SSD 61400212
AB7 (P&E)

STATE SIGNIFICANT DEVELOPMENT APPLICATION 61400212
APPLICANTS: Third.i Crows Nest Residential Developments Pty Ltd

2 SOUTH ELEVATION  
SCALE 1:200

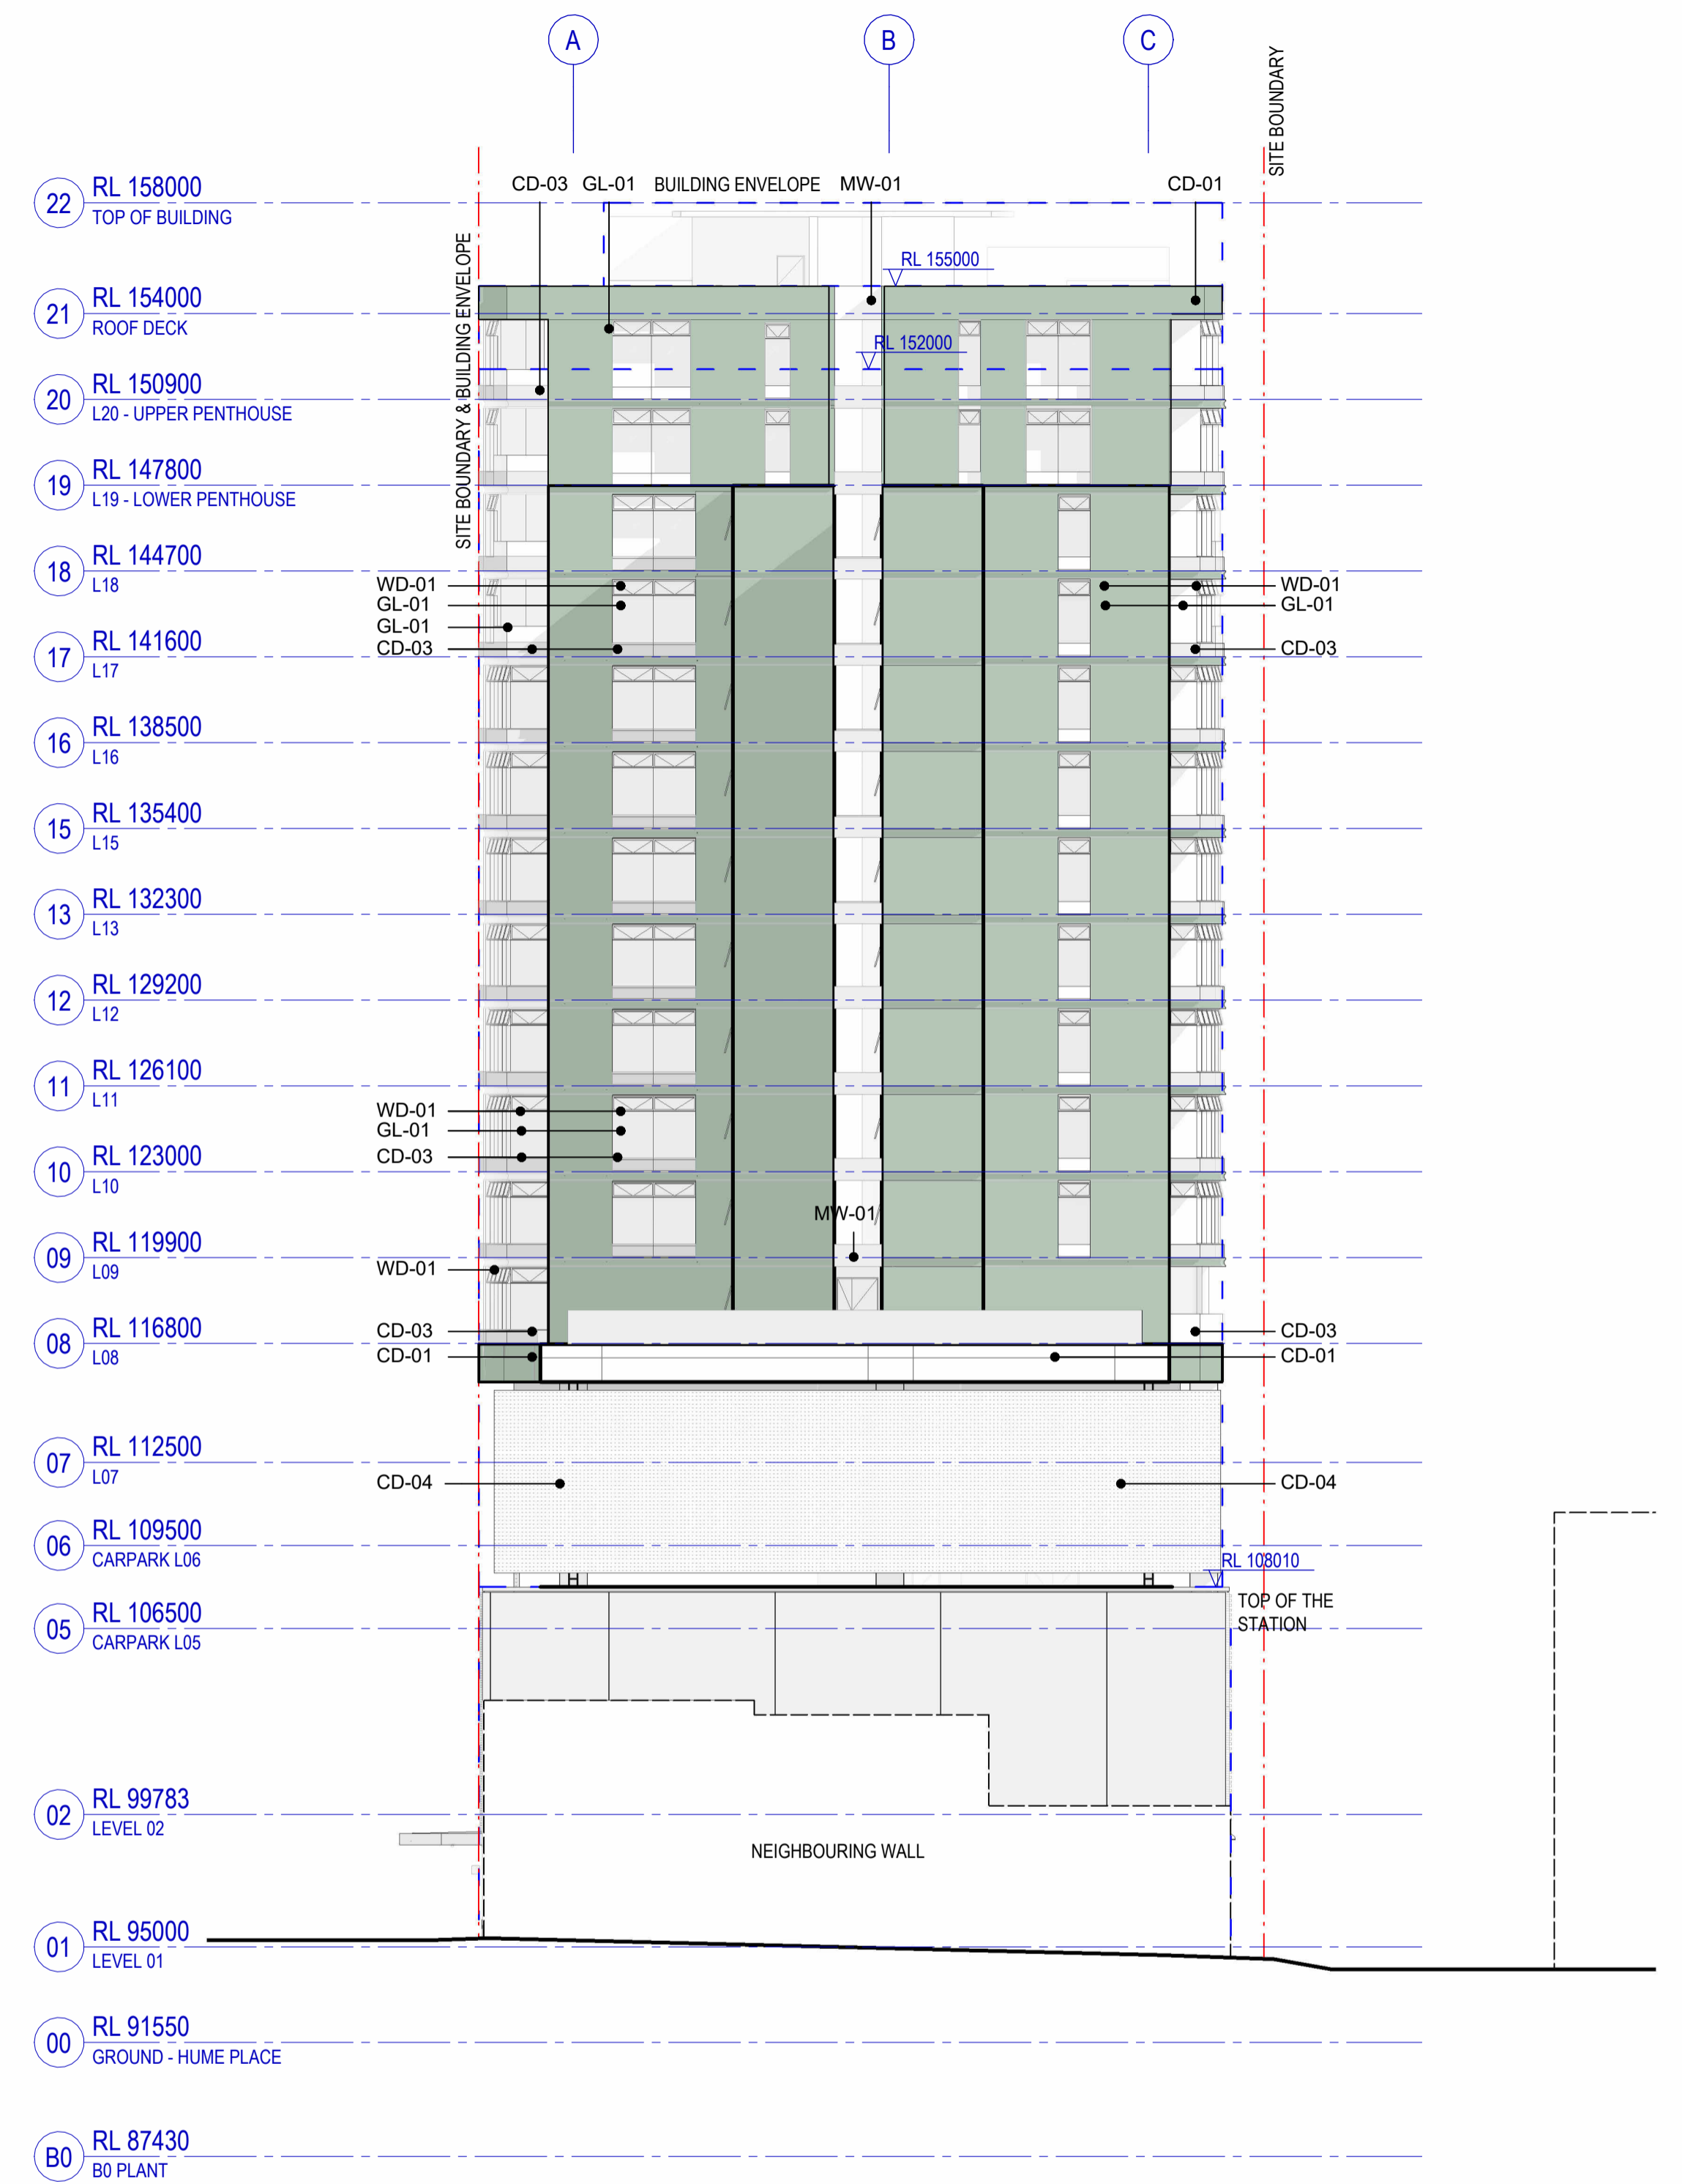
The proposed Site B building provides a setback of approximately 5–6.285m from habitable rooms to the southern site boundary for level 9-18, falling considerably short of the accepted minimum 12m setback requirement under the ADG and design recommendations of the Crows Nest TOD.

To mitigate these impacts and provide adequate amenity to the residential units, it is recommended that a minimum 12m building setback be provided by Site B along the shared southern boundary.
